Phone: 0300 123 6780
Email: Kathryn.Walsh@lancashire.gov.uk
Your ref: 3/2025/0038
Our ref: 3/2025/0038/HDC/KW
Date: 12 March 2025

Location: Units 3 3A 4 and 4A Cheetall Farm Clitheroe Road Bashall Eaves BB7 3LH
Proposal: Proposed demolition of single-storey rear and side extensions and conversion of barn to two dwellings with associated curtilage and parking areas.
Grid Ref: 371958 441992

Lancashire County Council acting as the Local Highway Authority (LHA) does not consider that the application as submitted fully assesses the highway impact of the proposed development and further information is required as set out in this response.

Job/Scheme Number		Drawing Number	
0755/93		Drawing No 07A	
Scale	Date	Drawn	Checked
1/250	Sept24	a.t.l-h.

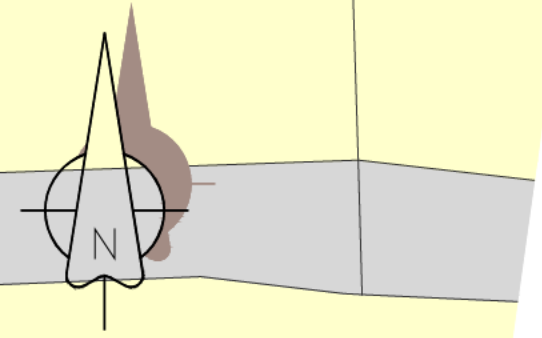
The LHA have reviewed drawing number No 0 7 B titled Proposed Site Plan (with GF plan) and whilst 2 off street parking spaces have been proposed to serve each dwelling, there are concerns regarding the proposed parking areas.

Unit 1's provisions are surrounded by a wall which will obstruct the use of the parking area, spaces should measure 2.4m x 5m and where they are adjacent to a fence or similar obstruction an additional width of 0.6m should be provided. Where the driveway is shared pedestrian access an additional 0.8m should be provided. A 3 bedroom dwelling should have at least 2 off street parking provisions to comply with the LHAs parking standards as defined in the Joint Lancashire Structure Plan

Unit 2 is a 4-bedroom dwelling and as such at least 3 off street parking provisions shall be provided to comply with the LHAs parking standards as defined in the Joint Lancashire Structure Plan.

Should the parking areas remain gated it is recommended the gates open inwards or are of a sliding type so as not to obstruct the private access road. To enable inward gates to work alongside the parking area, it is recommended the parking is set further back so that the gates can be operated with a vehicle parked.
